COUNTY COUNCIL'S RESPONSE TO CONSULTATION ON THE FOLLOWING DEVELOPMENT PROPOSAL

Application no: 19/01177/F

Proposal: Erection of 10 no. two-storey residential dwellings with access off South Side, including a new pedestrian footway, parking and garaging, landscaping, and all enabling and ancillary works.

Location: Land To The South And Adj To South Side Steeple Aston

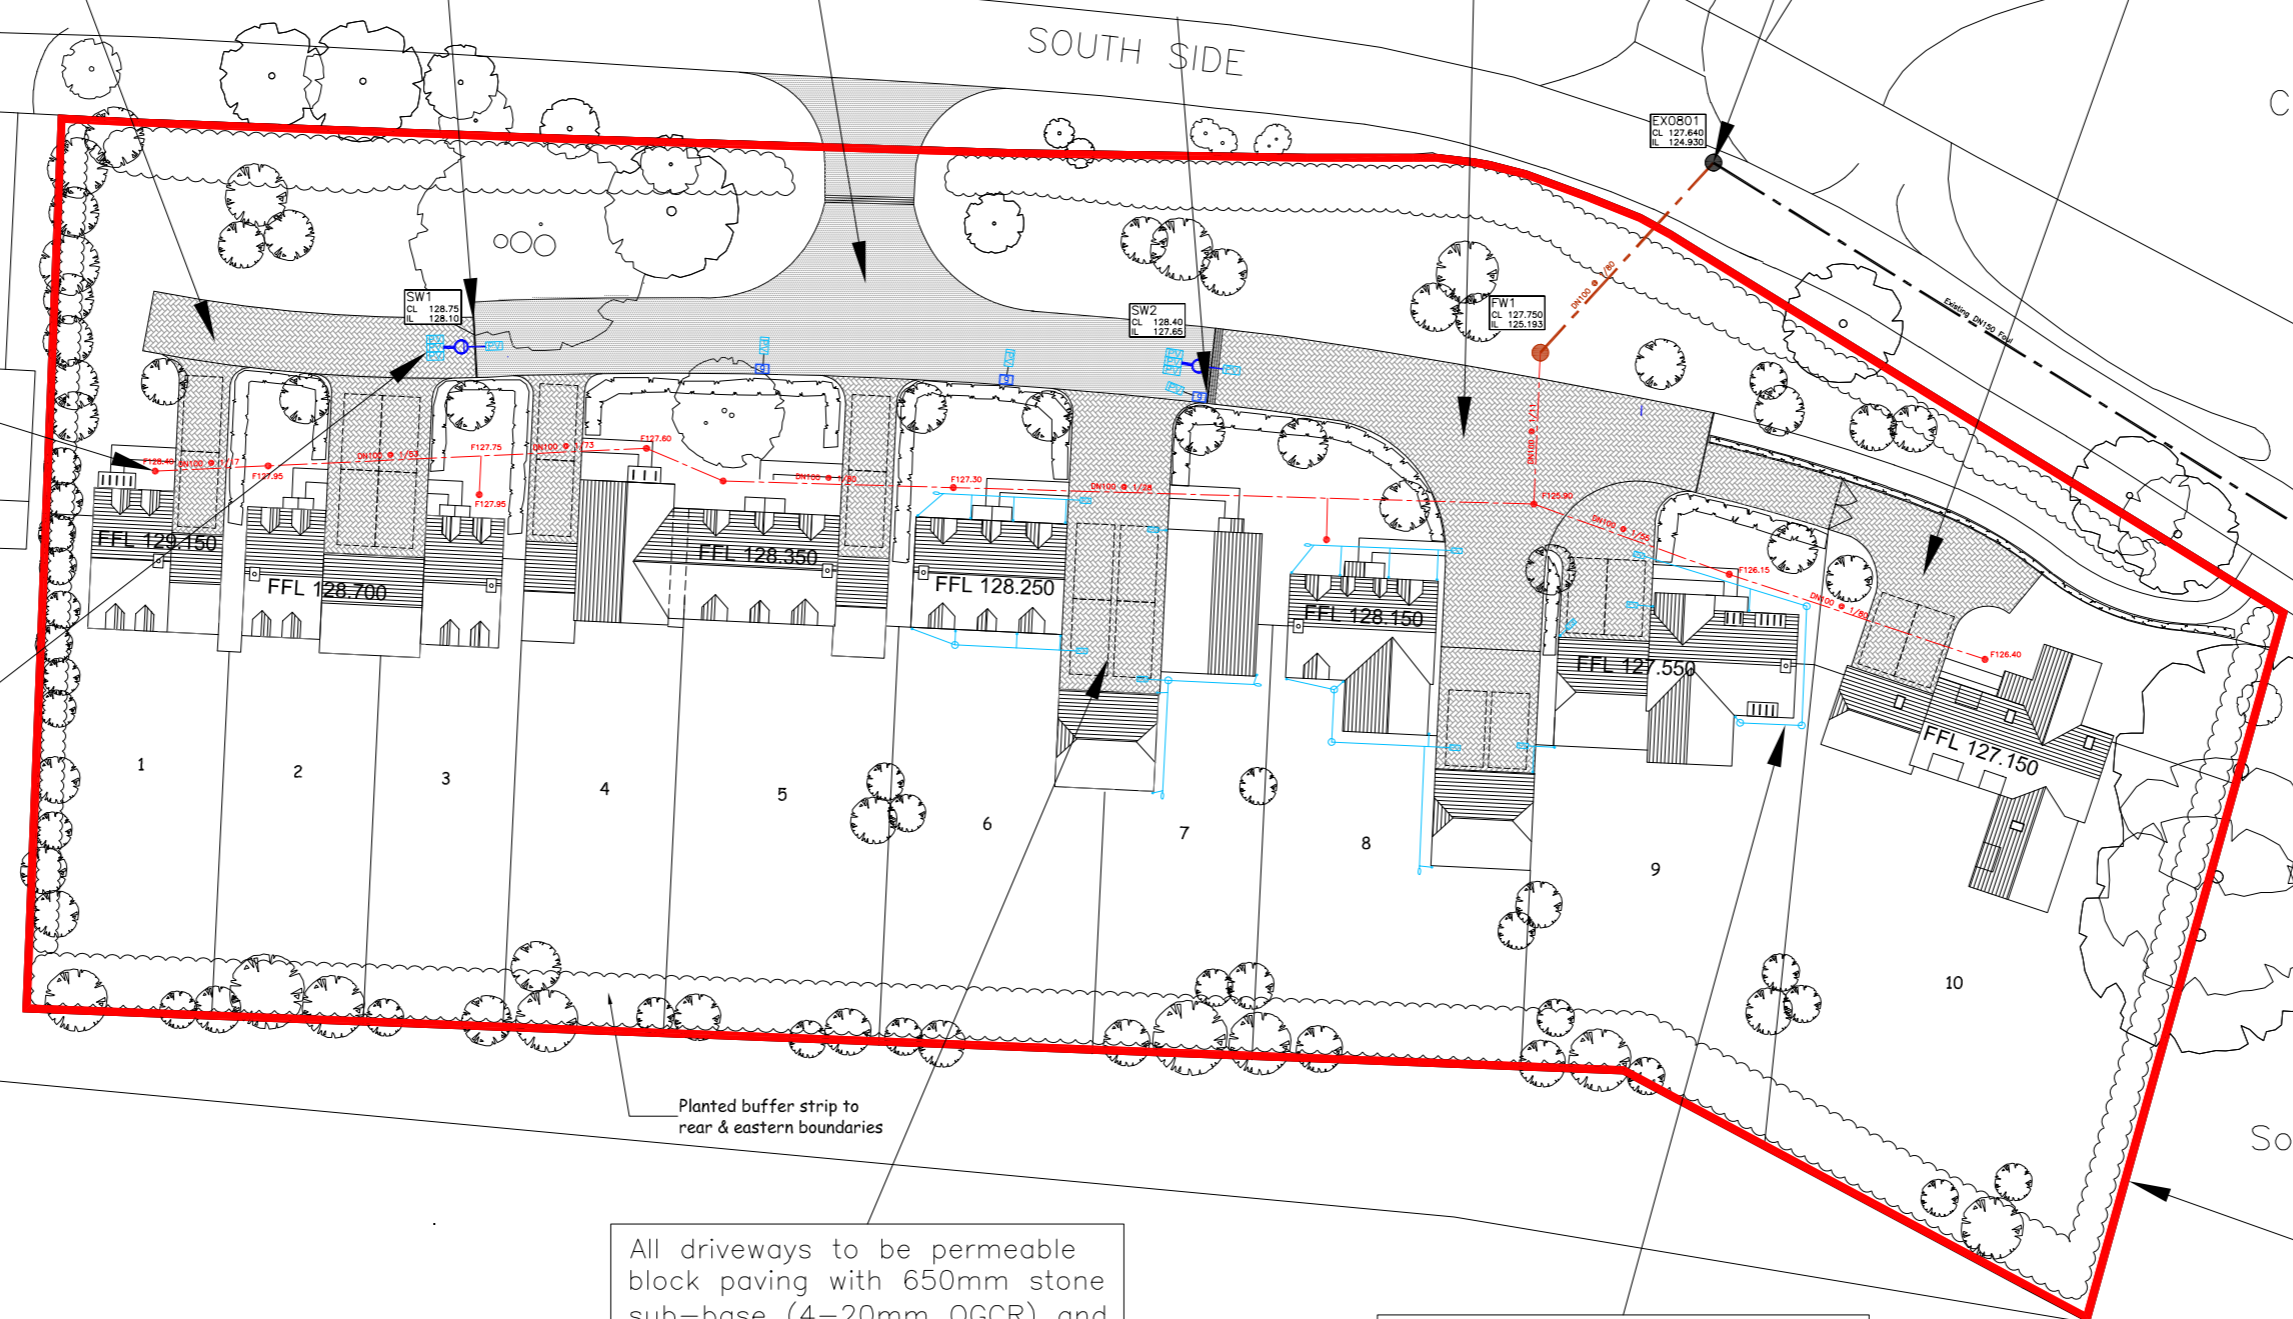
Section 4.7: Surcharging from piped network at limited locations, as stated, needs to be fully explained and justified. Where is this likely to happen, where will surcharged water go, what will be impact on rest of system.

The above in conjunction with the MicroDrainage Calculations which demonstrate Flood Risk on many sections of the pipe network needs to be explained fully and robust justification provided.

Written explanation as to how the piped sections will function under surcharge conditions, due to the MicroDrainage report indicating flooding on many sections needs to be robustly justified.
